From: Carol Reynolds
Sent: 22 February 2018 16:39
To: Planning.Responses
Cc: Anita Gardner
Subject: FW: Planning Consultation on: FG/206/17/PL

Environmental Health.

Site Address: Land at Asda Superstore Littlehampton Road Ferring BN12
 6PN

Description of Works: Installation of a Six Pump (12 Filling Position) Petrol Filling
station, Drive-to- Pay Kiosk & associated works including Jet
Wash, Air/ Water Services & Vacuum Equipment

Drawing Title
**PETROL FILLING STATION
FORECOURT LIGHTING PLOT**

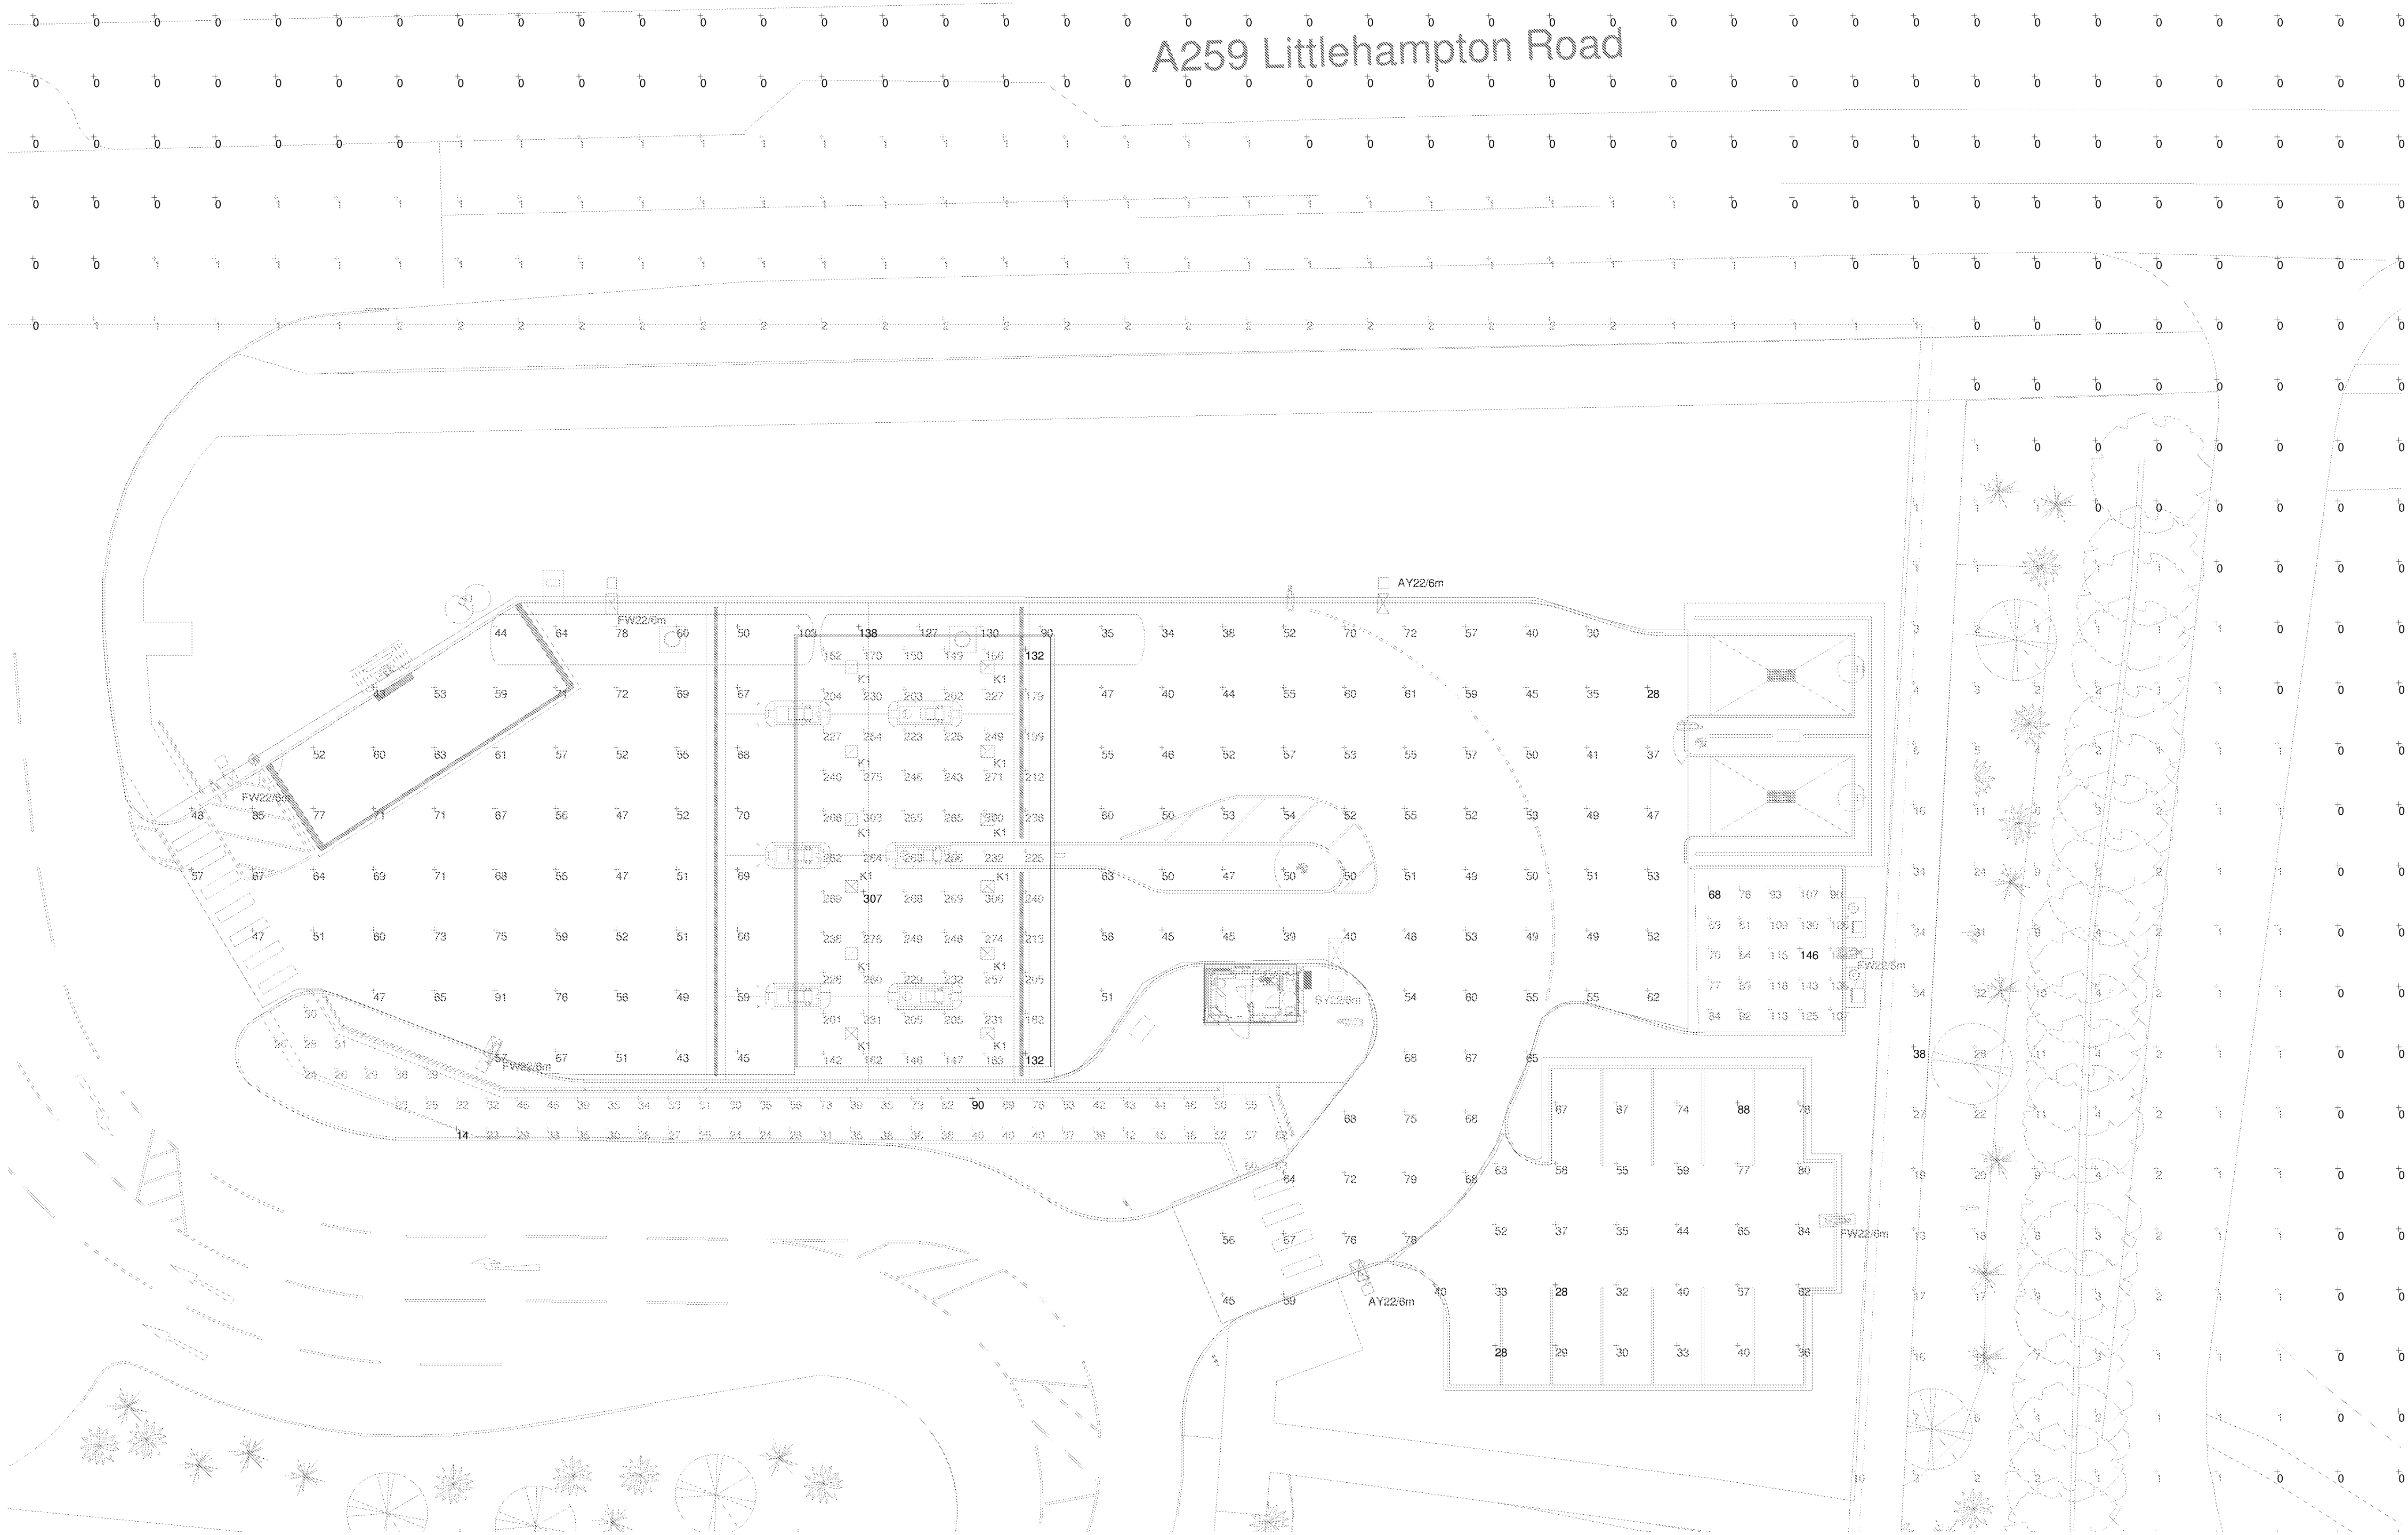
Lighting: External Lighting in association with this development shall comply with the Institute of Lighting Engineers Guidance Notes for the Reduction of Obtrusive Light, Obtrusive Light Limitations for Exterior Lighting Installations for Zone E3, Suburban. Special consideration to be given in respect of housing to the immediate east of this proposed development.
